Engineers Comments Regarding Surface Water Drainage

Application Reference:	P/59/25/DOC	Reviewer Reference:	ADC/EXT2/D2134/80
Planning Officer:	Amber Willard	Date of Review:	13.11.2025
Site Name:	Sefter Farm Pagham Road Pagham PO21 3PX		
Application Description:	Approval of details reserved by condition imposed under reference P/117/21/PL relating to condition number 7 - surface water drainage scheme.		
Assessment Number:	2 of 2

CLIENT	Barfoots Of Botley
PROJECT	Sefter Farm East
TITLE	Site Layout - Surface Finishes - Sheet 2

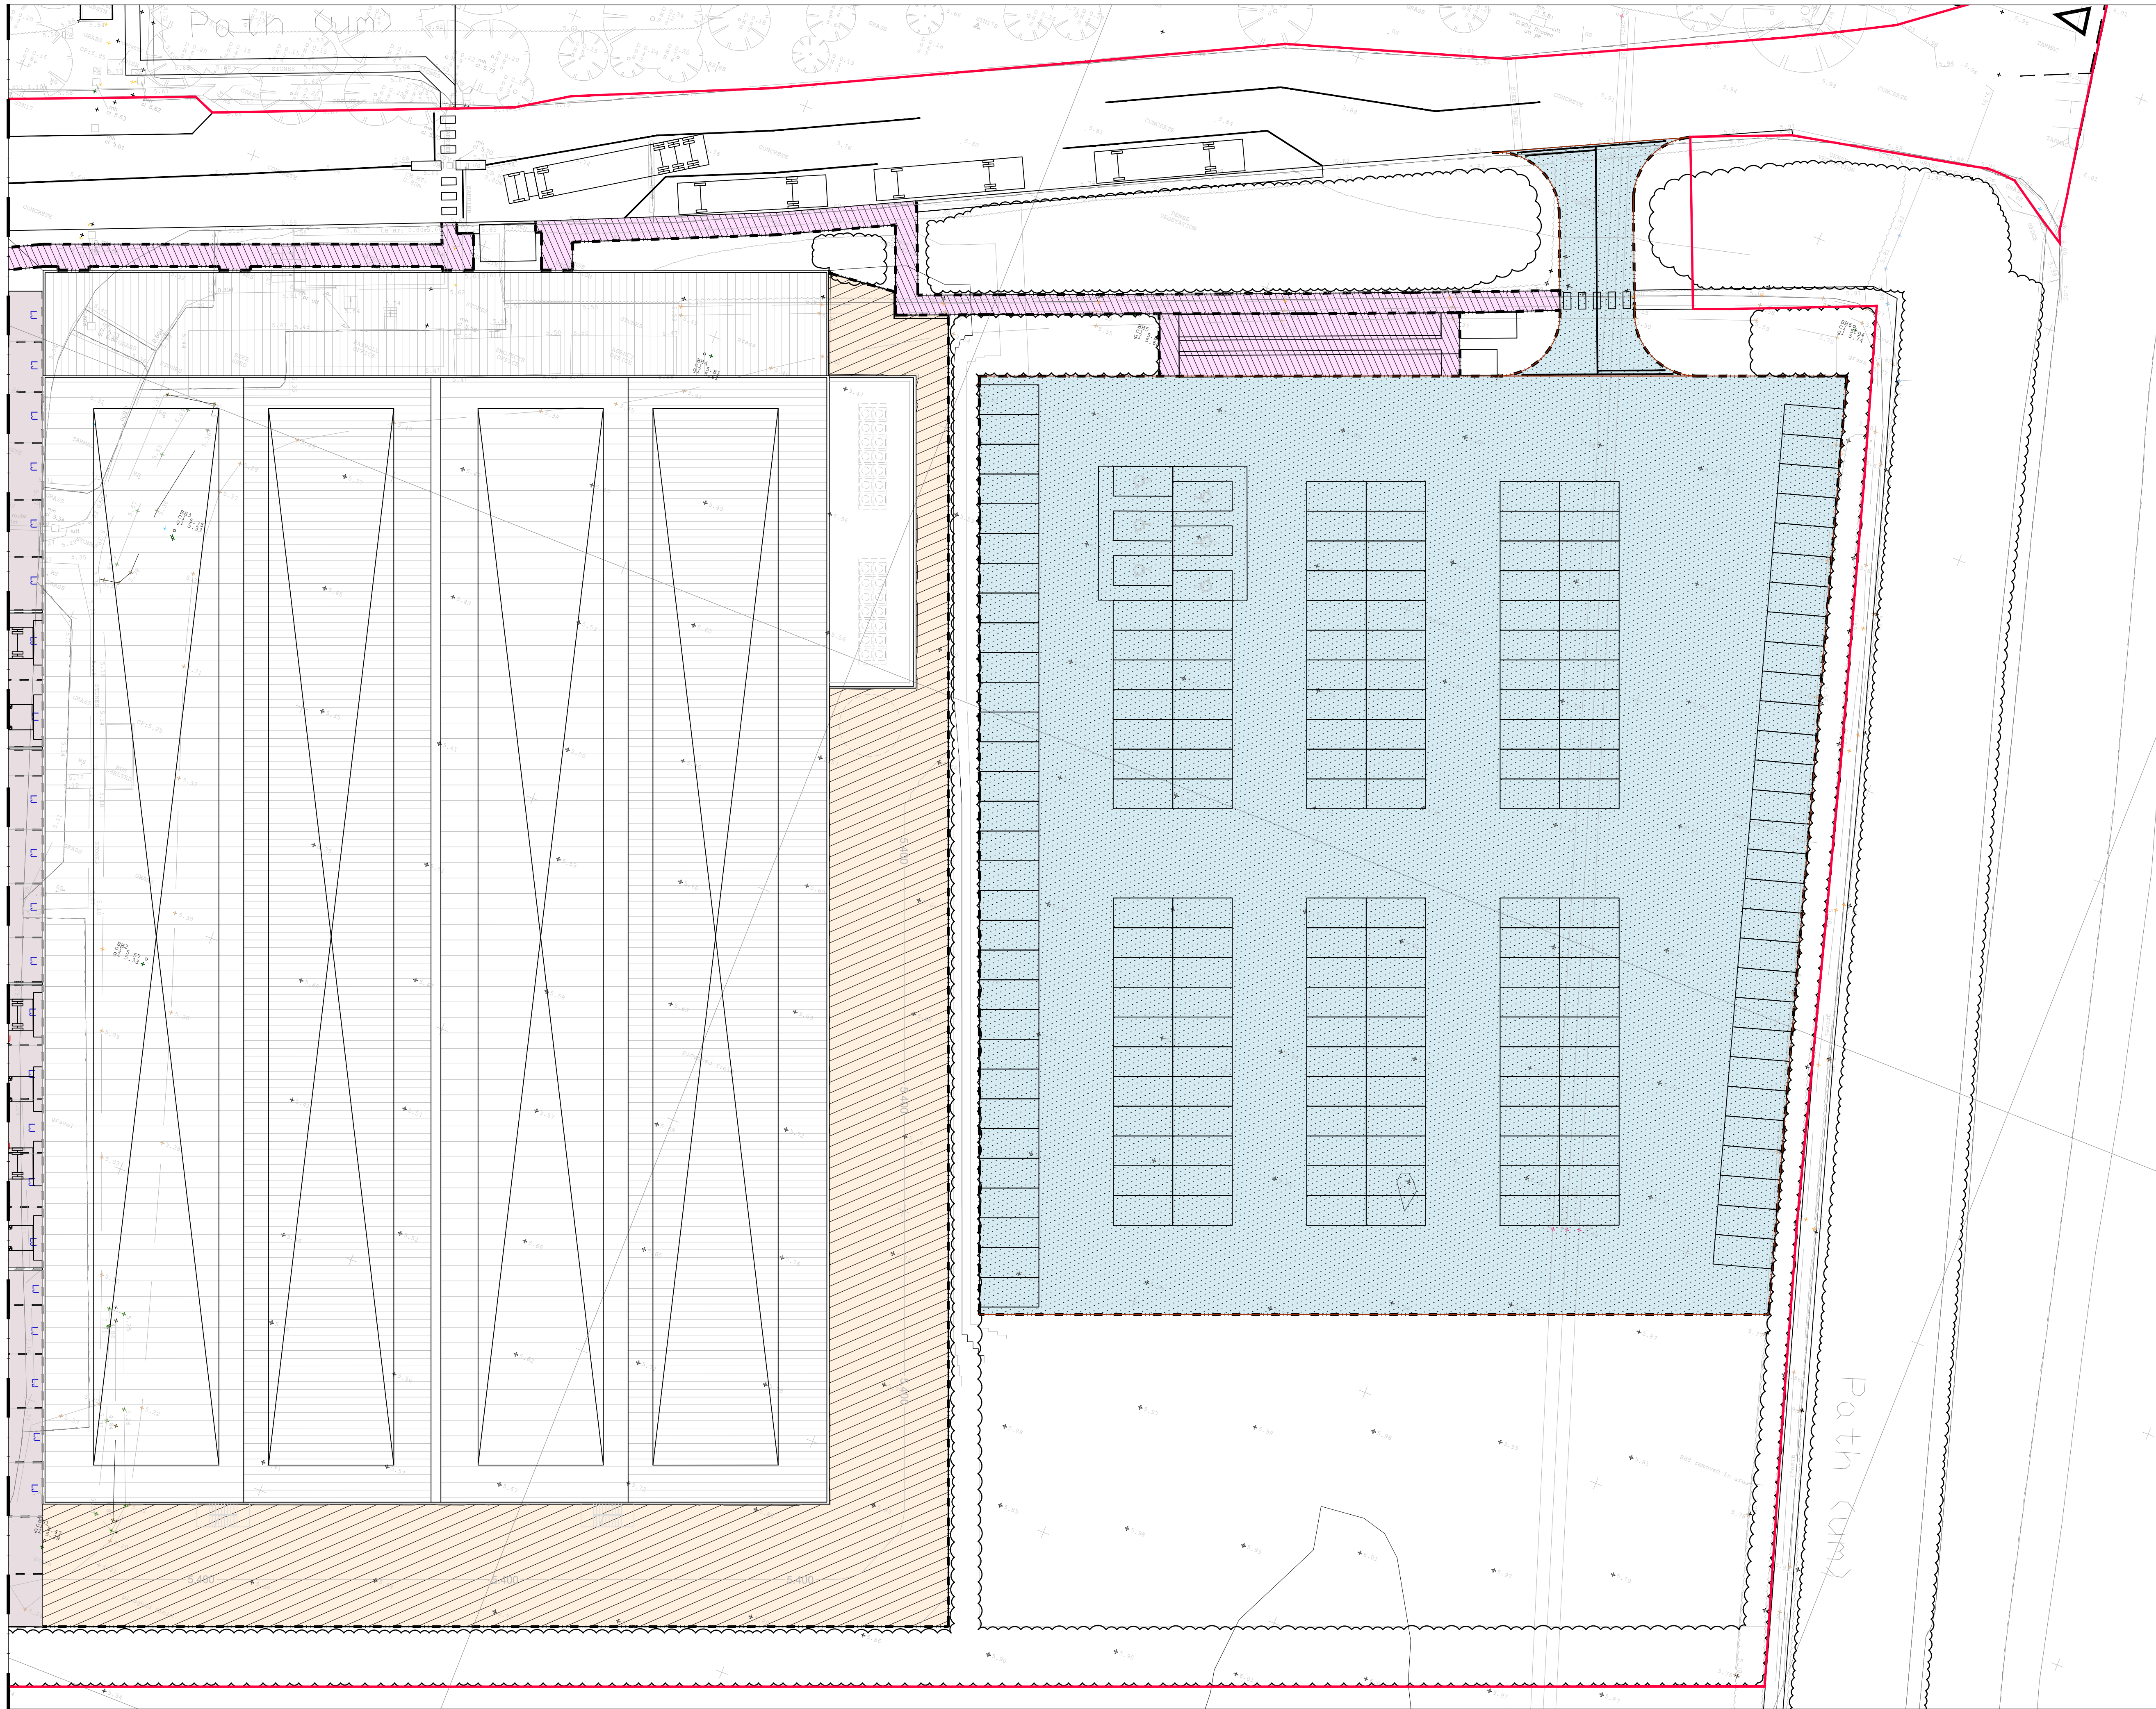
9.	Whilst the proposed yard and permeable parking are proposed to be laid very flat, the site sections nor surface finishes highlight any boundary kerbs/edging which may have a role in controlling run-off, please confirm.	The permeable paving is to be constructed over voided subbase which by definition is constructed below ground level. No edgings are required to retain below ground storage, impermeable membrane is noted on the Construction Details Surface Finishes Drawing 501 submitted with the application and copy attached. The membrane is shown at the base and the edges of the permeable stone to retain the surface water within the system below ground. There are also edgings shown where relevant on the surface finishes detailed design drawings submitted with the Discharge of Conditions application.	Noted, however the edge restraint/support must be fit for purpose i.e vehicular loading along the edge. The construction details on 501 must be updated to demonstrate how the edging will be installed to the outer edges permeable pavement. Comment outstanding.

11.	Permeable pavement construction details must be updated to qualify kerbs/edgings.	As previously noted: There are edgings shown where relevant on the surface finishes detailed design drawings submitted with the Discharge of Conditions application. Please see Surface Finishes Drawings 24019-401 and 24019-402	Please see response to comment 9 above. Comment outstanding.

Please see Surface Finishes Drawings 24019-401 and 24019-402, copies attached.			
10.	Please provide supplier details/quotes for all flow control devices/sump requirements.	All flow controls are orifice plates. These can be sourced from a multitude of suppliers. There are no hydroborates or bespoke flow control devices propose on this scheme. Flow control manhole construction details have been added to Drawing 511 C, copy attached	National Standards advises <i>'3.22 Where the peak allowable discharge rate requires flow controls with orifices (or equivalent) with a diameter of less than 50mm, the flow control shall be robustly protected from blockage risks. Regardless of this, the risk of blockage for all flow controls shall be assessed and mitigated against'</i> The bespoke flow control details on drawing 511, with 40mm size are a relaxation to the above clause and therefore the designer must clarify on how the risk of block has been assessed and mitigated. This may also require further clarification for maintenance. Comment outstanding.
